From: [Toni Berkshire](#)
To: [Rachael Stevie \(CD\)](#)
Subject: RE: RU-22-00002 East Peak - Notice of Application
Date: Thursday, April 7, 2022 8:40:01 AM
Attachments: [image001.png](#)

Regarding: Reasonable Use Exception RU-22-00002 East Peak

Re: RU 22-00002

SUBJECT: RU-22-00002 East Peak

Exhibit D - Mitigation Plan

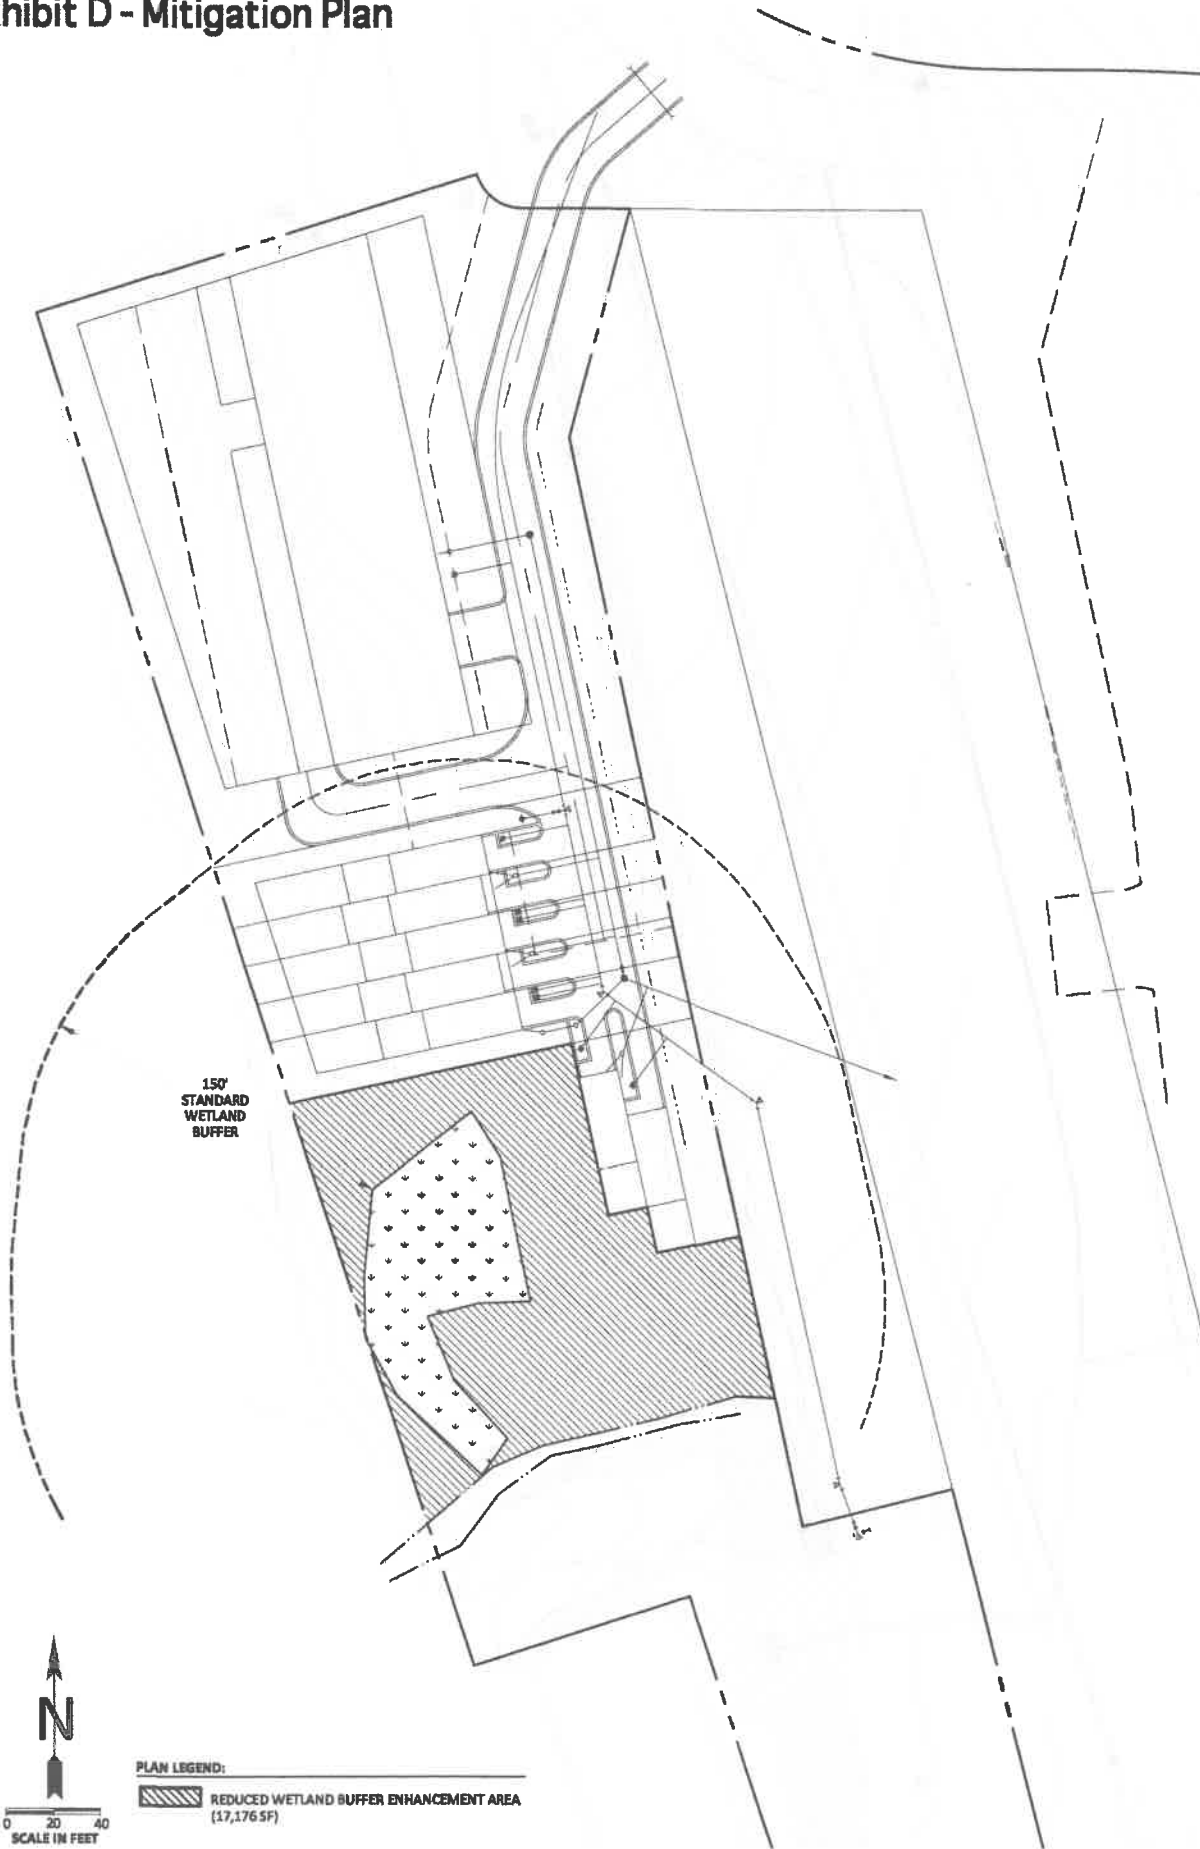
In reading the Wetland Buffer enhancement plan, I noted that it stated that the wetlands would be cleaned of gravel. My concern is that the wetland would continue to see snow removal thrown onto the enhanced buffer. In fact with reduced area for snow removal due to the new buildings, the wetland area would more than likely become the primary snow holding area for the parking lot resulting in a further degradation of the wetland area.

- It is unclear what width the buffer is being reduced to.
 - The planting plan proposes the use of three tree species. It should include shrubs and an herbaceous layer as well for added structure, screening, and filtering purposes.

- Monitoring of planted woody material should be for 10 years with the potential for early release if meeting performance standards.
- Goals and Objectives of the overall mitigation monitoring plan should be included. It needs to be expanded on beyond that of Year 2.

Exhibit B - PUD Site Plan

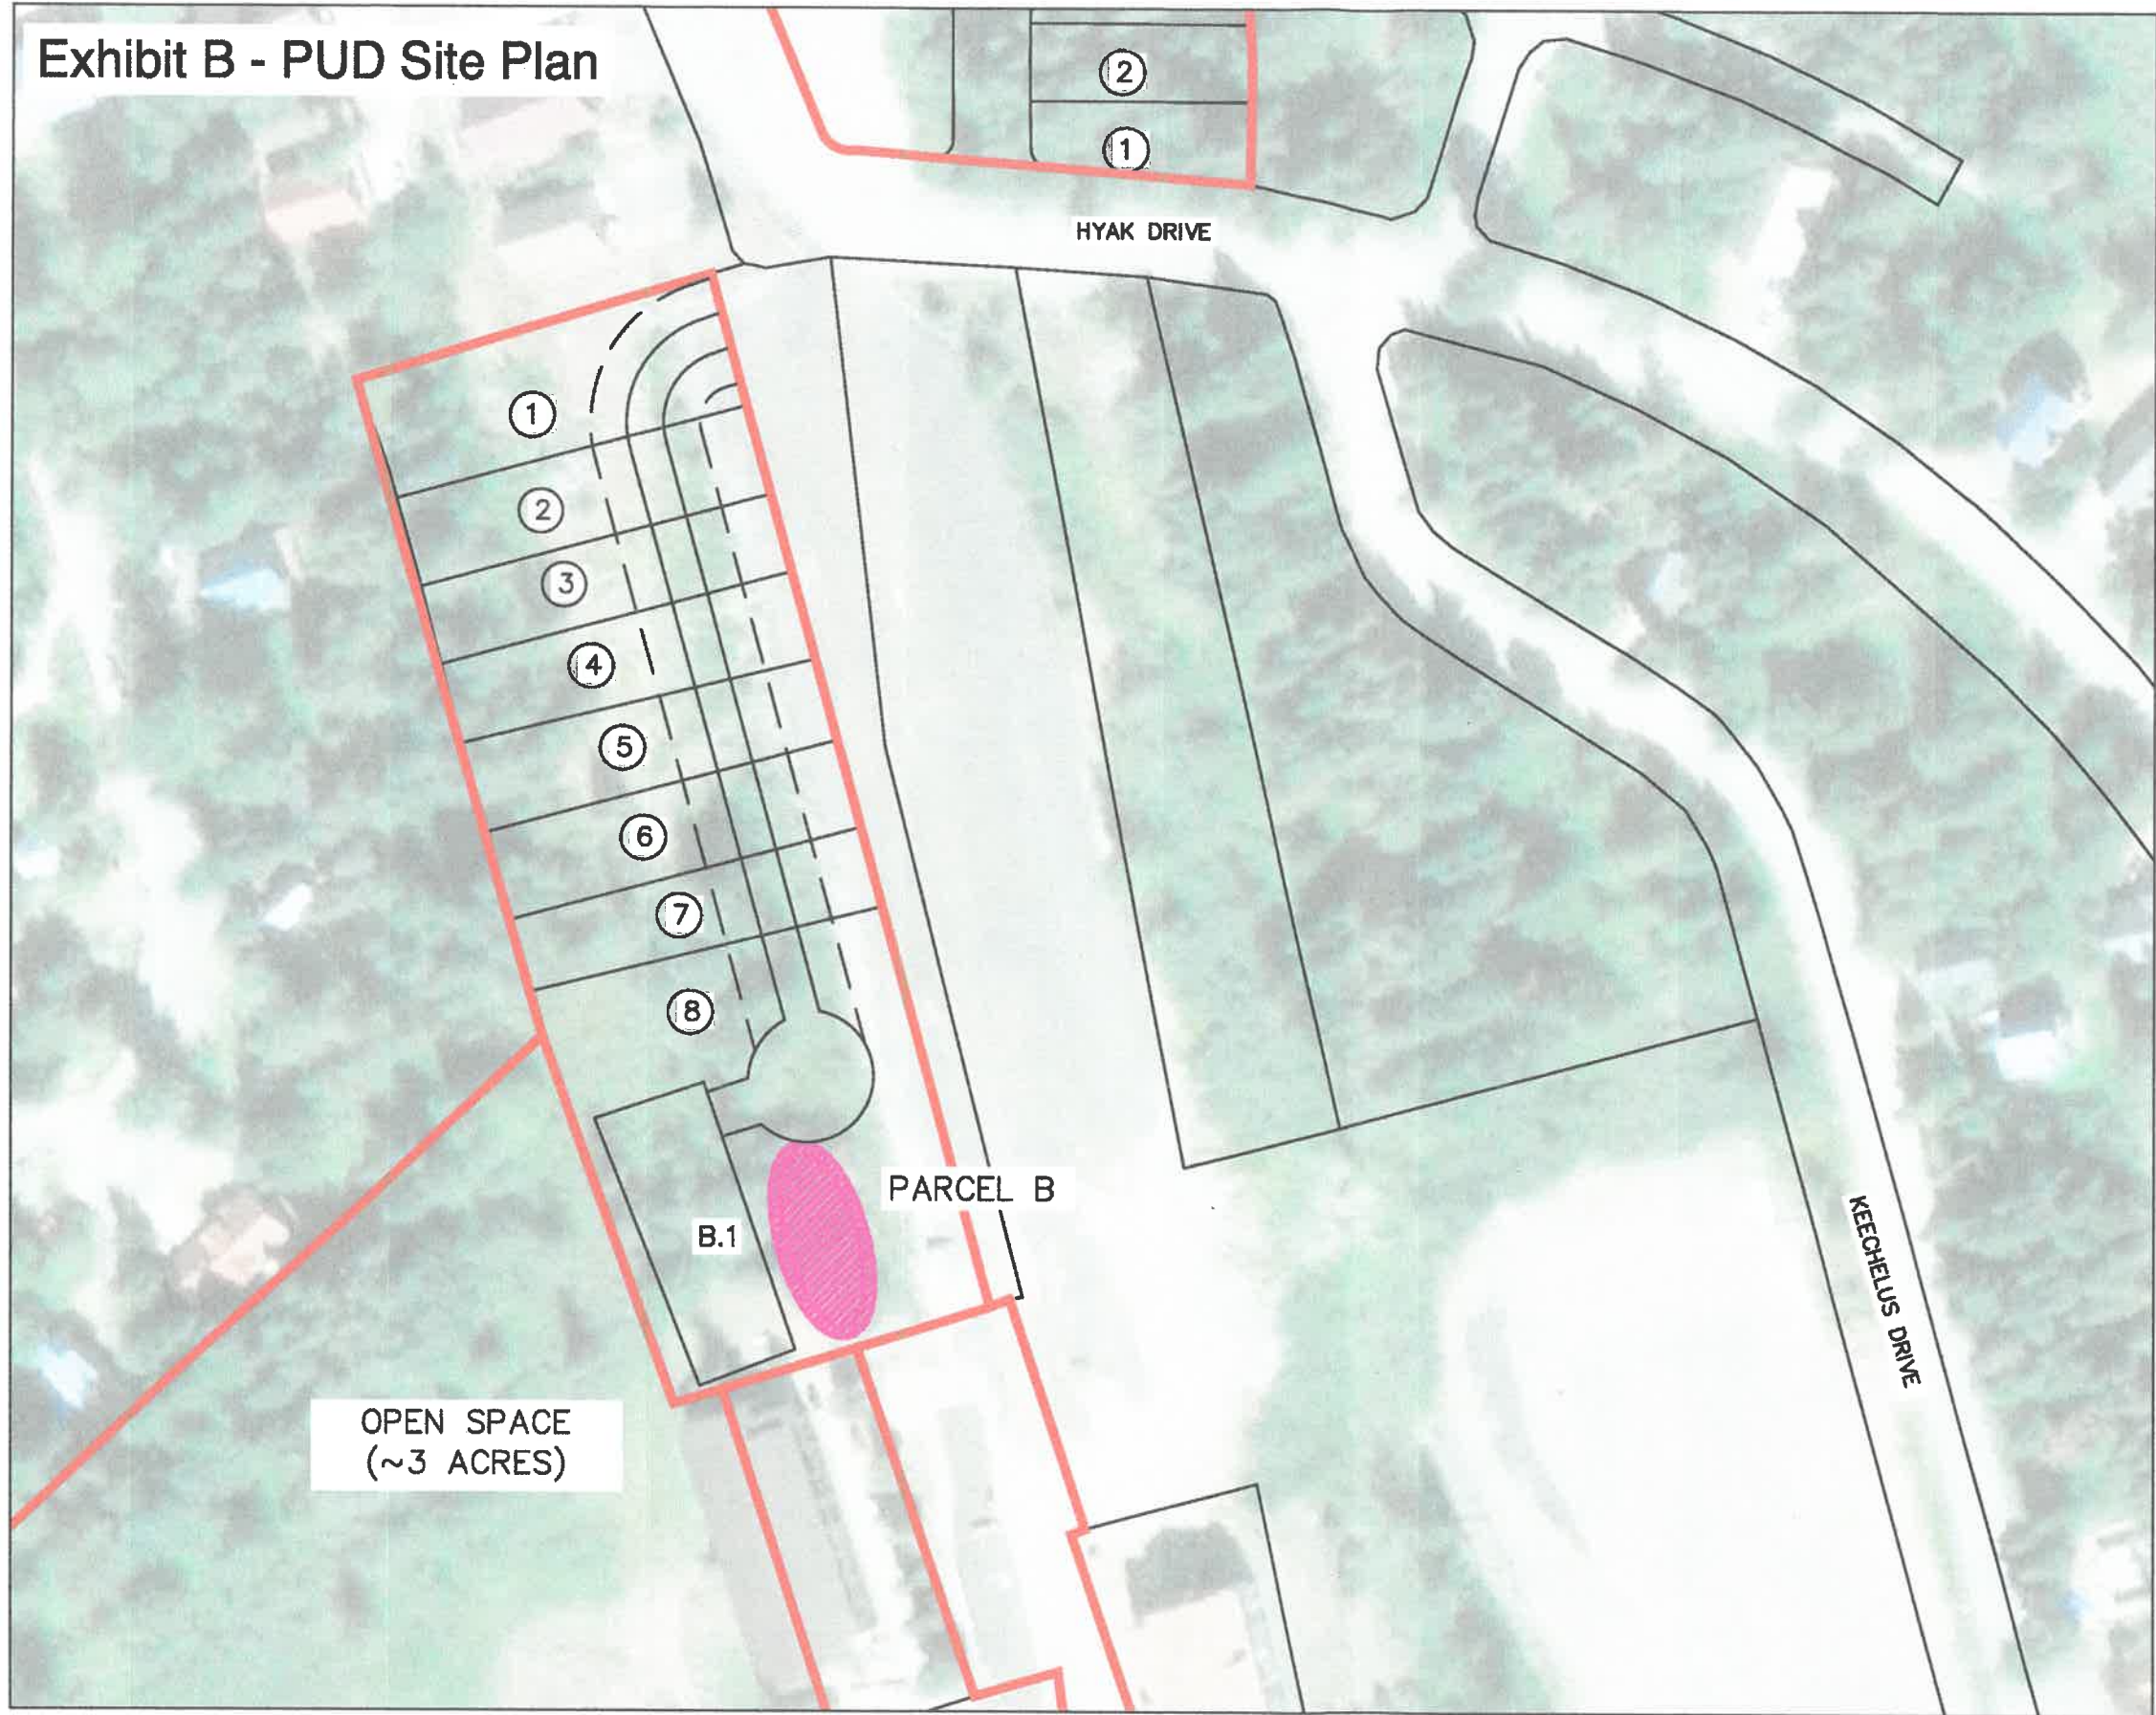
In the "Project Narrative" for the Reasonable Use Variance, East Peak Development, LLC states in their response the Hyak PUD Final Development Plan was approved in 2018 by the Kittitas County board of Commissioners showing a 50 unit condo building and 8 detached single family lots. It further states "The approved density was based on an in-depth analysis of surrounding uses". However, during the "in-depth analysis" the original project plan failed to identify the wetland which the proposed 50 unit condo building was to be constructed upon.

EXHIBIT A - PROPOSED SITE PLAN

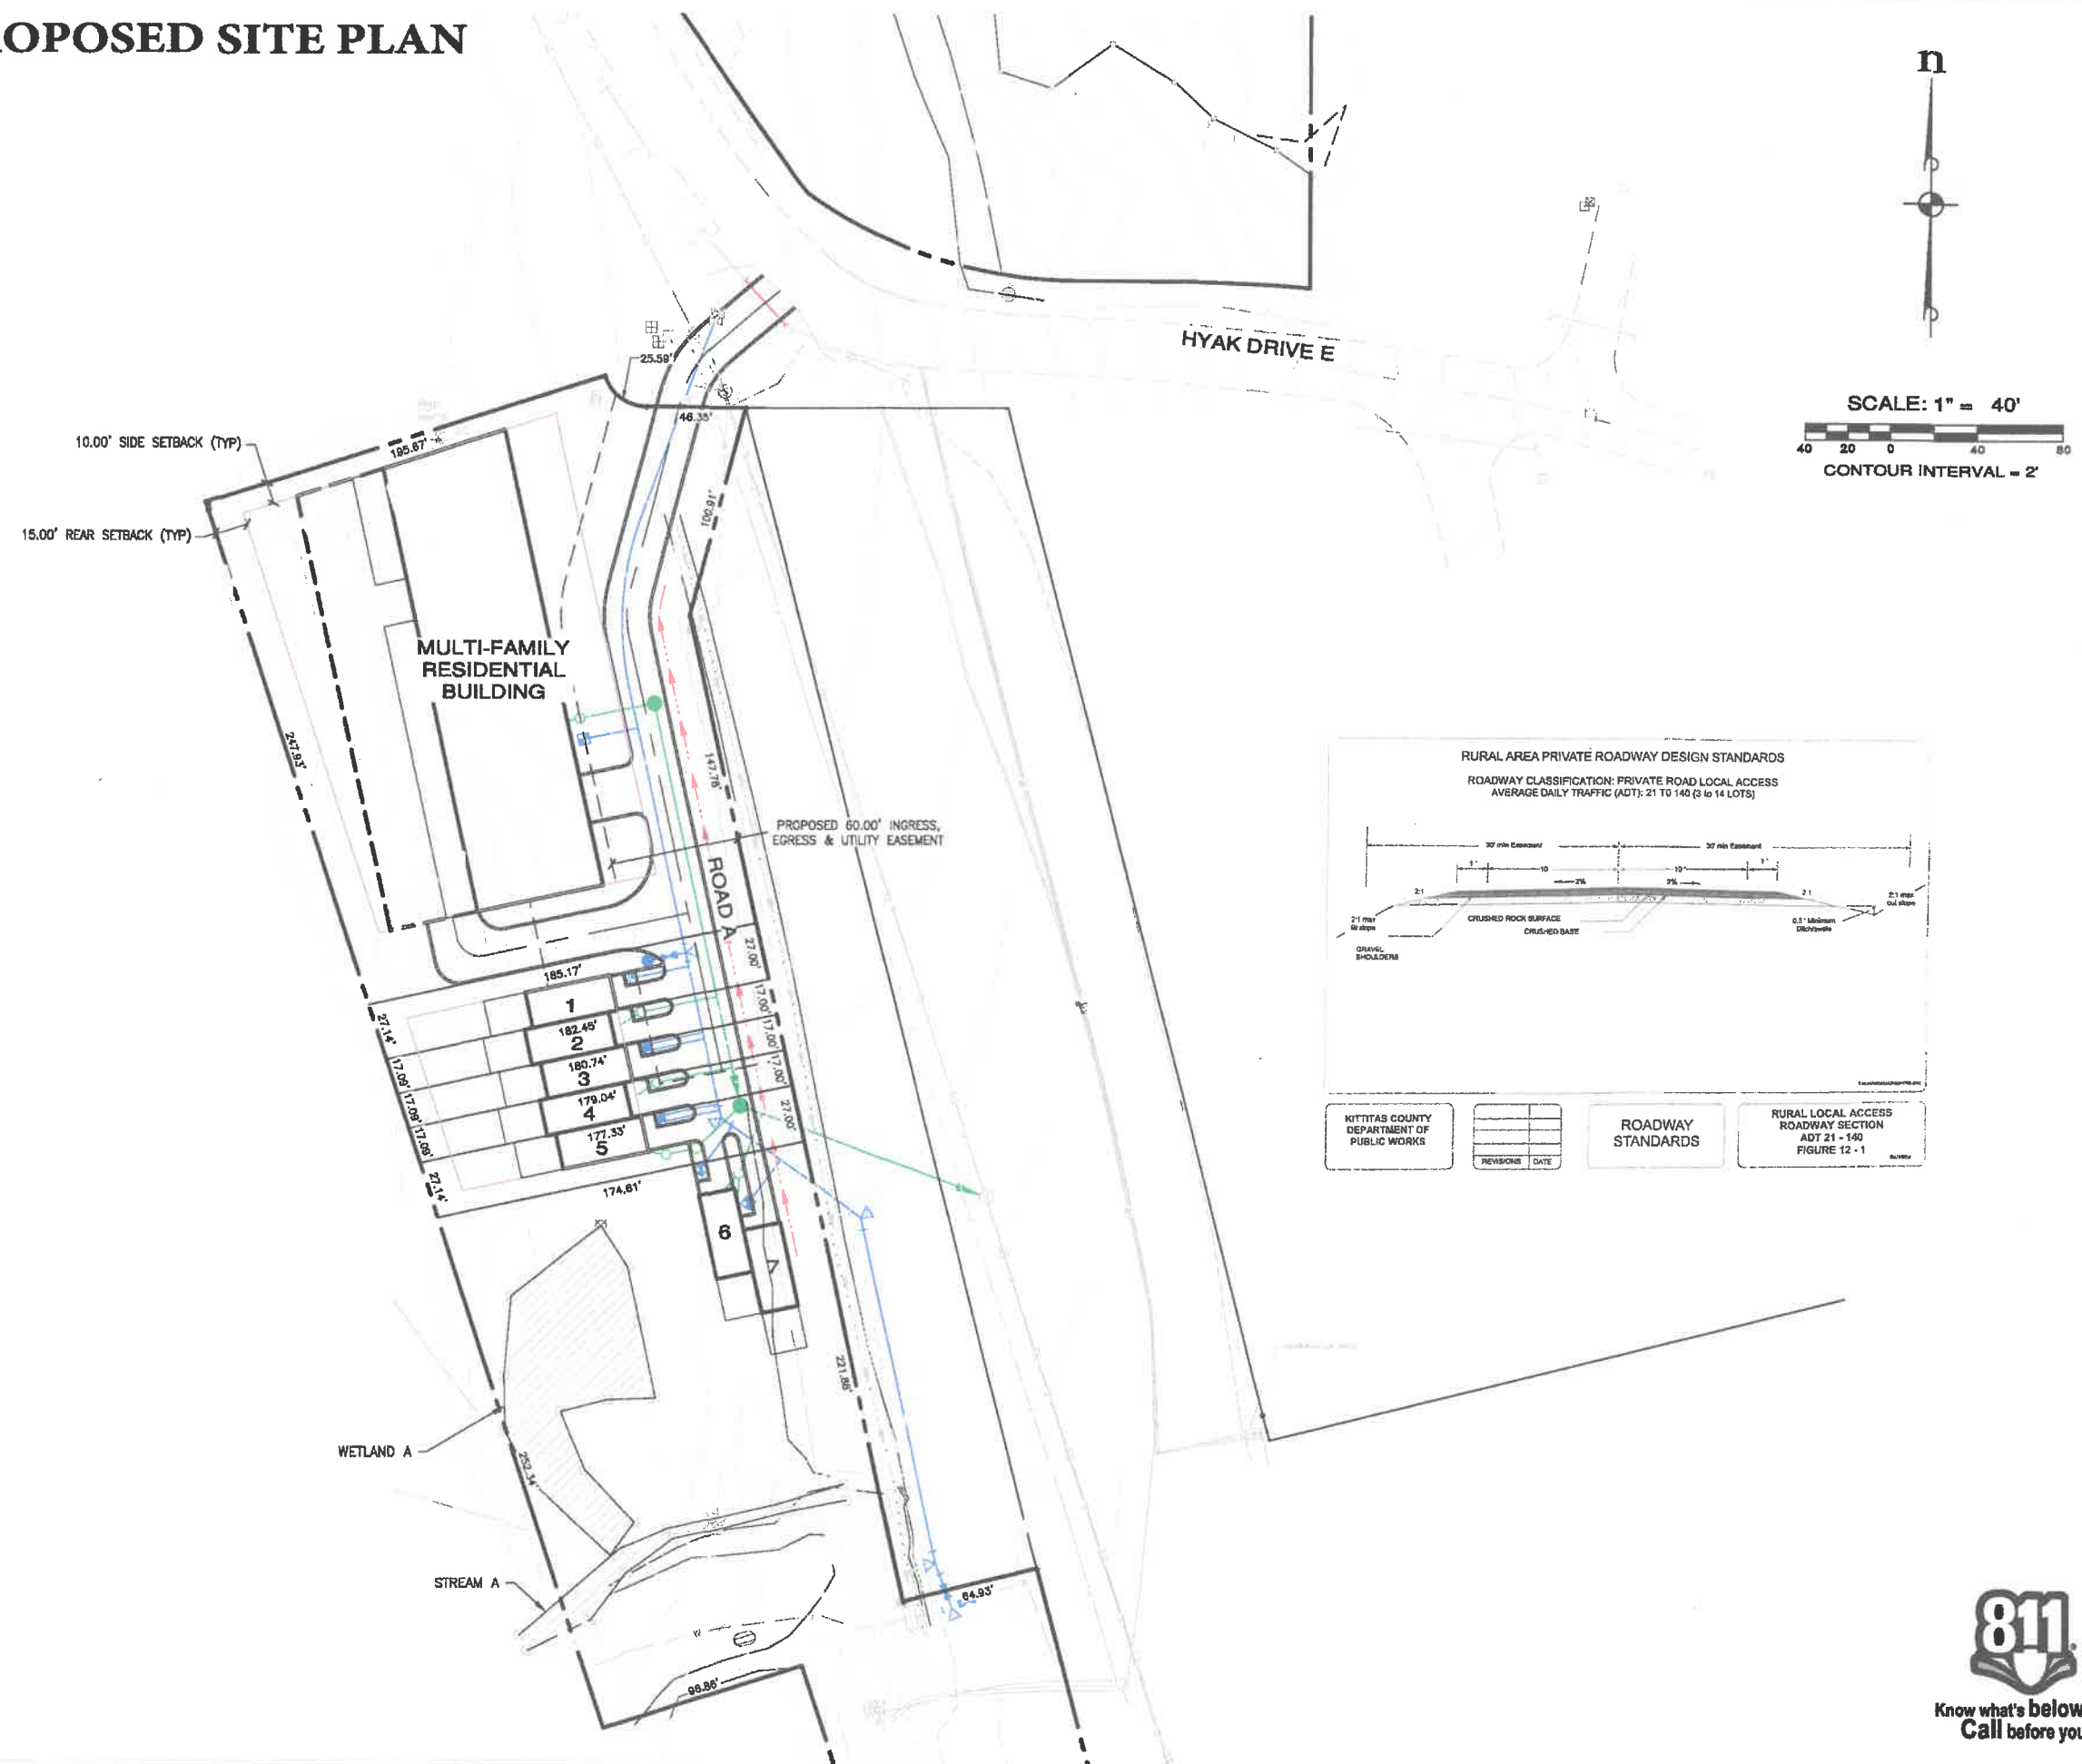
In regards to the reduced wetland buffer, I find it odd that none of the documentation seems to specify the final reduced buffer. The original buffer for a type 3 wetland is indicated at 150 feet plus 15 foot setback. In looking at the Proposed Site Plan the distance is not called out, but it appears that the type 3 wetland buffer has been reduced from 150 feet to 25 feet with a ten foot building setback. This seems to be an extreme reduction in the buffer zone. A total reduction of approximately 125 feet. The primary reason for the reduction does not appear to have any environmental rational. The only reason given in asking for the reasonable use exception is that East Peak development would like to maximize their financial return on this project. Nowhere in the wetland evaluation does it mention that this is a newly created wetland, so it must be assumed that this wetland was present when East Peak originally purchased this land and it would seem that they should have conducted due diligence prior to purchasing this particular plat. It does not seem that Kittitas County should be required to waive environmental standards solely that East Peak can maximize its profit. With regards to the current real estate market it would seem probable that, even if the buildable plat is reduced by 40 to 50 percent, the project should maintain a healthy profit.

In regards to flipping the design layout, with the condominium at the North end, it appears that this may have a negative effect for the existing residential homes on Chamonix Pl. Nowhere in the plans does it indicate the height of the proposed condo, but I would imagine that having a 40 to 60 foot tall building will have a detrimental effect on existing housing located due west and north of the condo.
